Fwd: 1363 Washington Ave

Thank you for sending the final detail sheet for this project that includes the dumpster enclosure. I have copied this to Malia and Kyle as all of the other submissions have come through them to me.

**Bollard** 6/08  
N.T.S. Source: VHB LD\_700

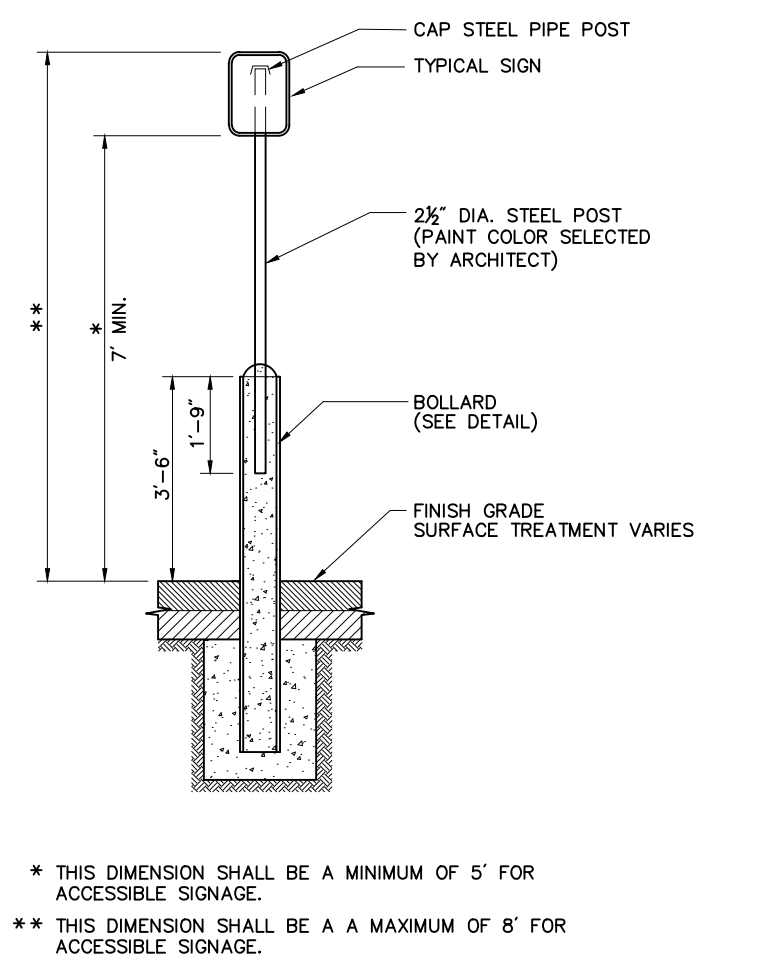
I would note that the detail for the bollard does not match the one that is on the approved plan C5 (attached)- not a big issue but where are the bollards being located- is it really necessary for them to be painted bright yellow and be 4 feet high?

PLAN VIEW 1/4" = 1'-0" **1**

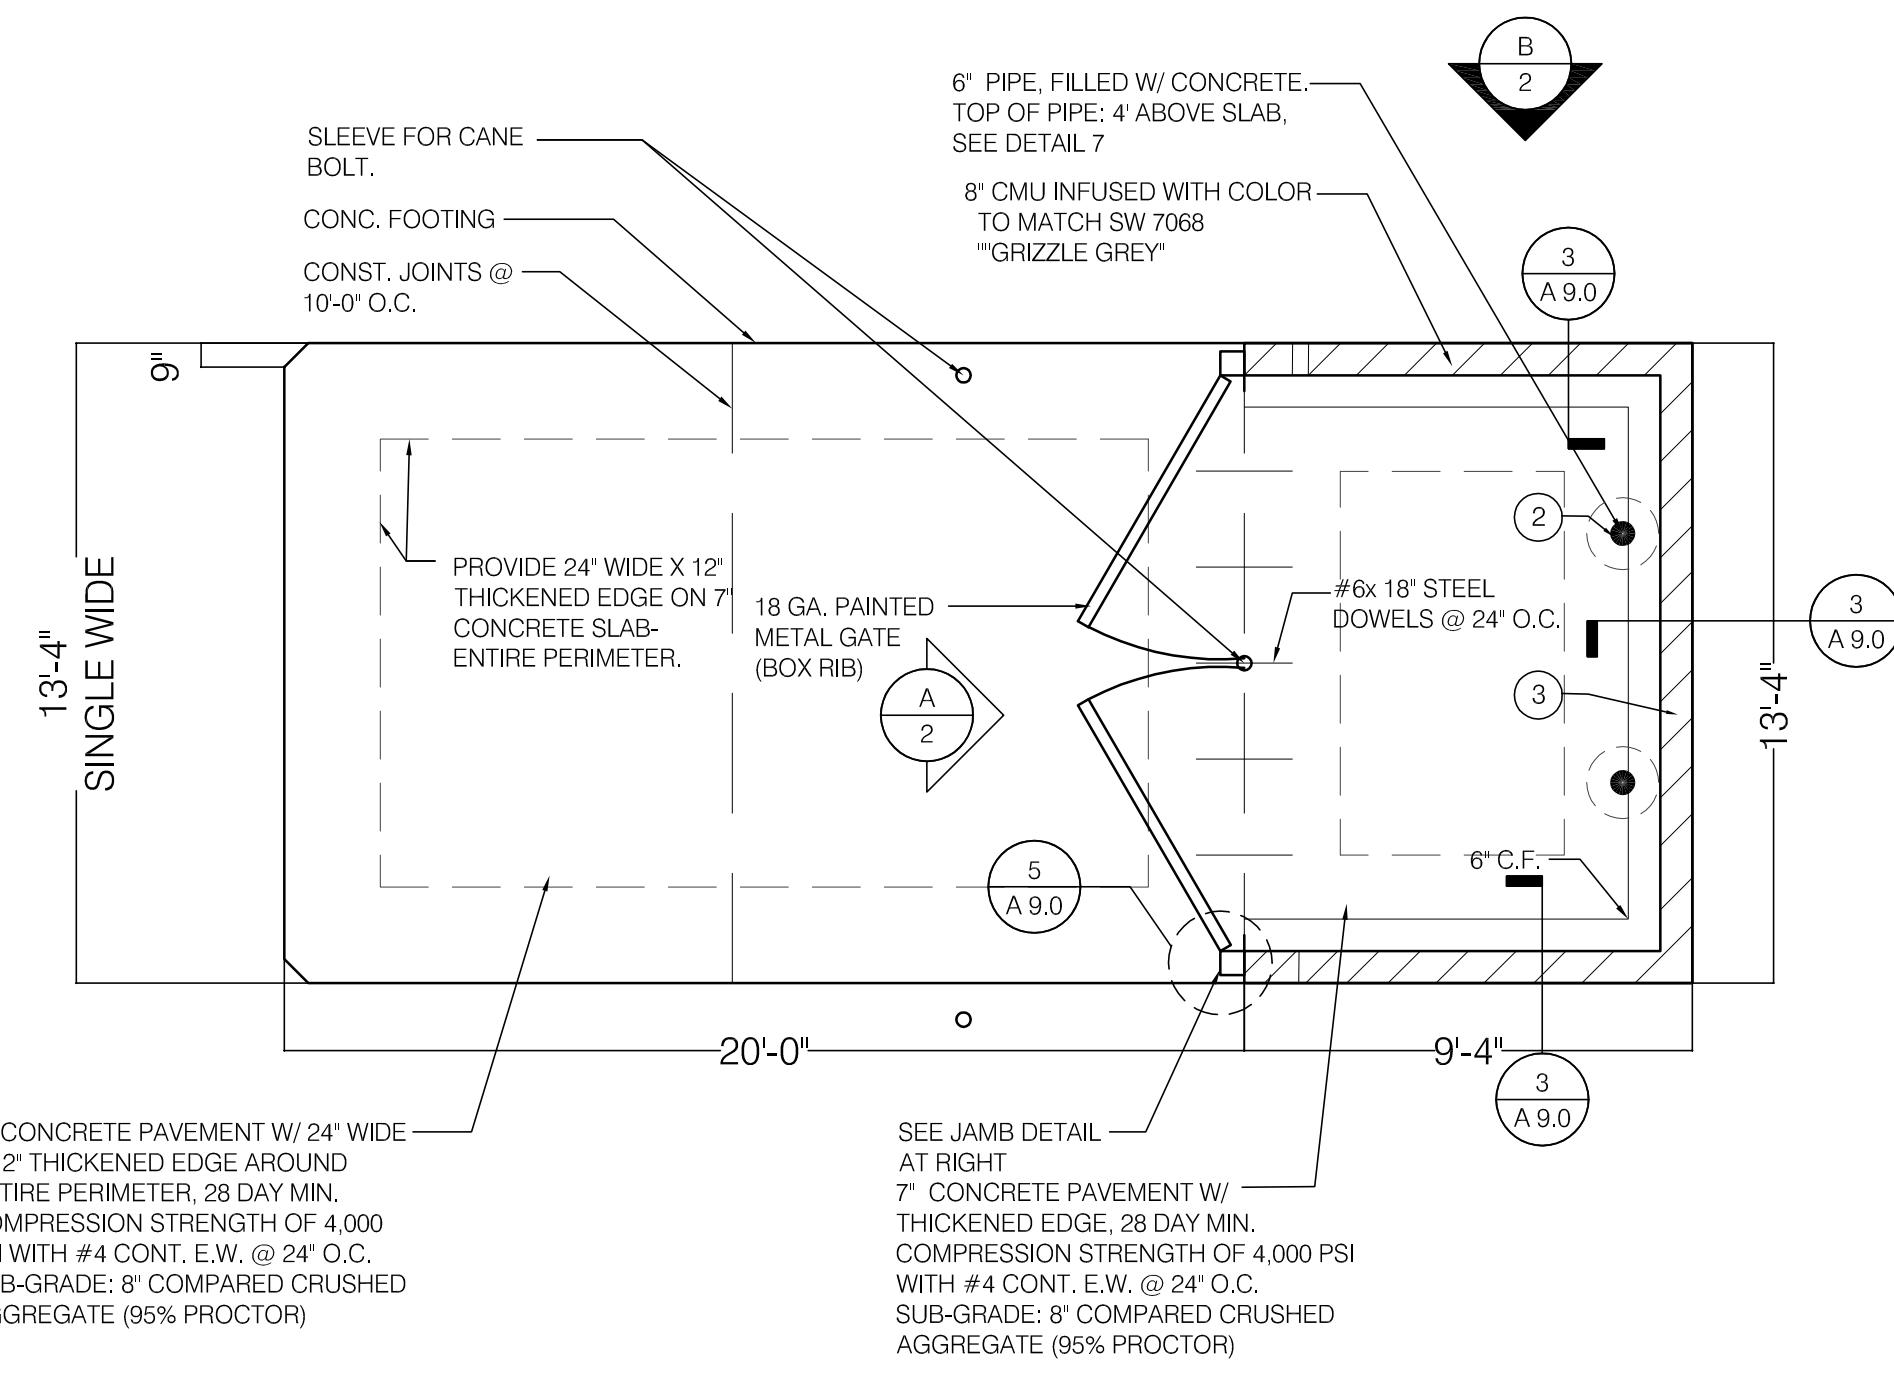
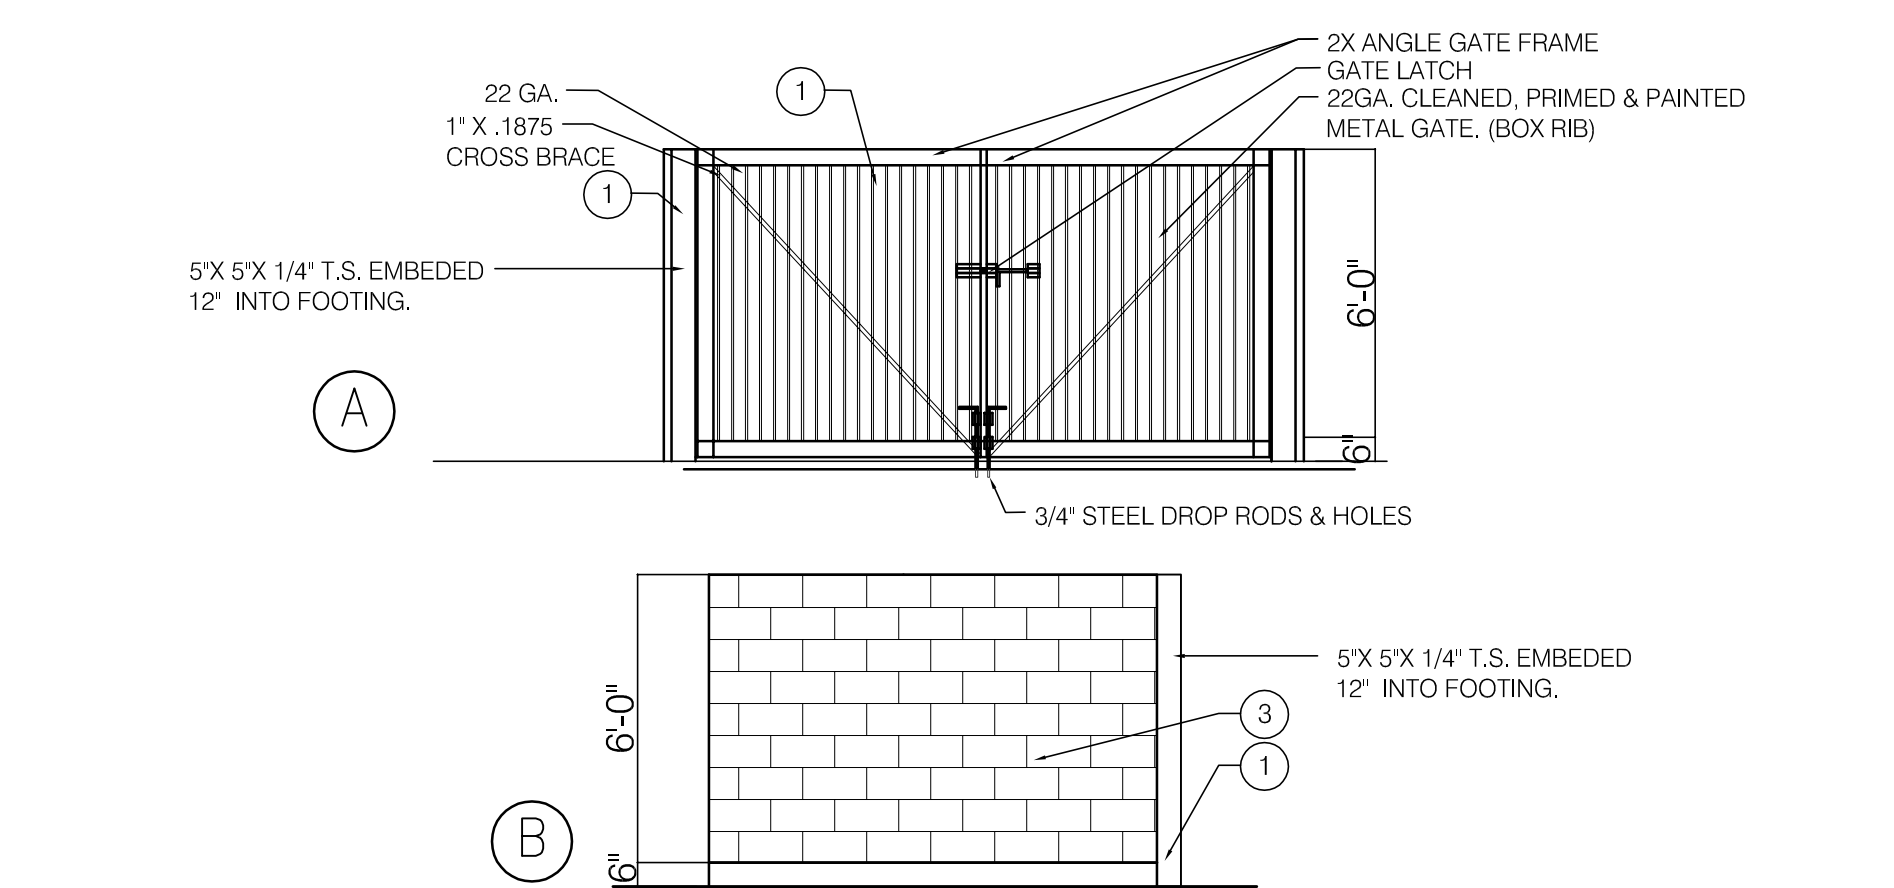
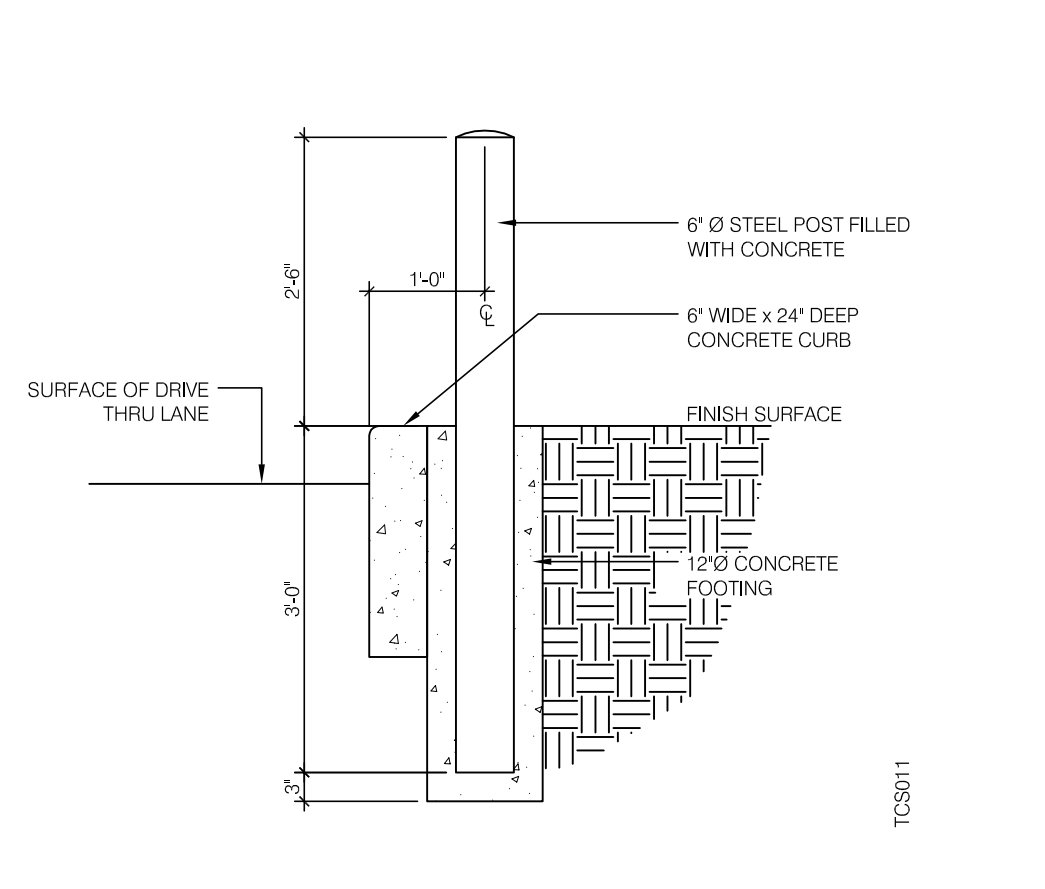
Regarding the dumpster detail- the objective is for the dumpster to be screened and hidden if possible- this is an urban area with lots of pedestrians and nearby buildings/users so it should not be highlighted with yellow posts etc.

What is the material on the sides and back?

Could you please revise to confirm the material on the side and back of the enclosure and remove at least some of the bright yellow and if possible introduce some planting on the side facing Washington Avenue.
